Whitstable Fishermen's Association
West Quay
Whitstable Harbour
Kent CT5 1AB

22 October 2026

Sea Link Project (EN020026) – Comments on responses to the Secretary of State's request for information dated 28 August 2026

Figure 1: Kent and Essex IFCA District, Thames Estuary Cockle Fishery Order 2024 (TECFO24) and the Cockle Fishery Flexible Permit Byelaw (CFFPB), cockle fishery management areas, and the Sea Link Project Boundary-EN020026.

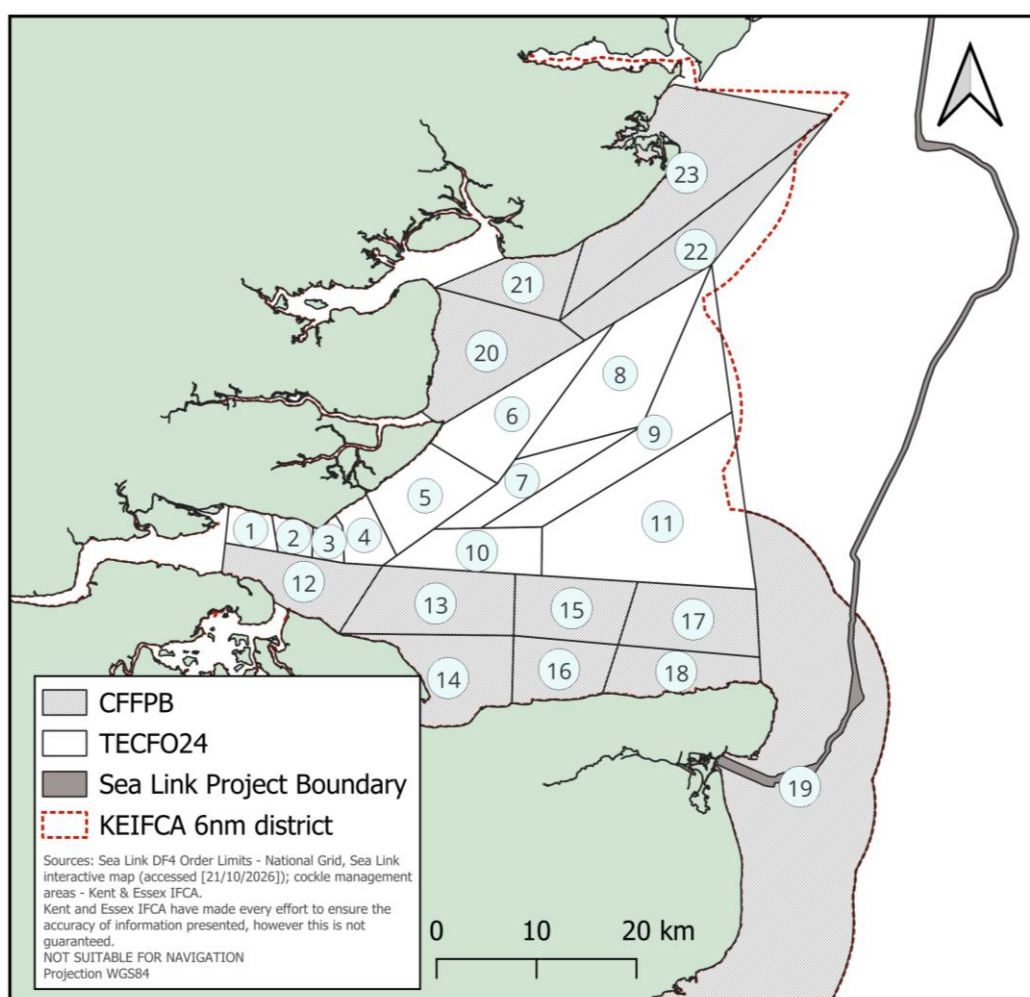
5. KEIFCA's indicative mapping places Thames Estuary cockle Areas 22 and 23 approximately 8.5 km from the nearest offshore project boundary, with Areas 18,

17 and 11 within approximately 10 km. These beds support the WFA's members and the wider Thames Estuary cockle fishery.

6. The Applicant has not set out when, or for how long, seabed-disturbing works (including trenching, jetting and sandwave clearance) will take place in the parts of the route nearest these beds, or how that programme relates to the cockle fishing season and the spat settlement period. Distance alone does not establish that there will be no effect. The Applicant's own Marine Conservation Zone Assessment (section 1.5.10) states that plumes of fine sand, silt and clay from jetting during cable installation could extend up to 11 km, which places all these beds within the potential range of sediment plumes. Cockles are filter feeders, and fine sediment mobilised on a spring tide can travel considerable distances before settling.

7. The WFA therefore asks the Secretary of State to require the Applicant to:
 - set out the indicative timing and duration of seabed works on the sections of route nearest Areas 22, 23, 18, 17 and 11

- confirm whether its sediment plume modelling, under spring tide conditions, extends to these beds, and if so what suspended sediment and deposition levels are predicted there

- avoid the most disruptive seabed works on these sections during spat settlement and the peak of the fishing season or, where that is not practicable, explain why; and

- monitor suspended sediment during these works, with a defined trigger for notifying KEIFCA and the fishing associations.
 - Where the wider construction programme cannot be adjusted around the cockle season, manage the timing of jetting in areas of finer material around the tide, for example jetting on the ebb, to reduce sediment transport towards the cockle grounds
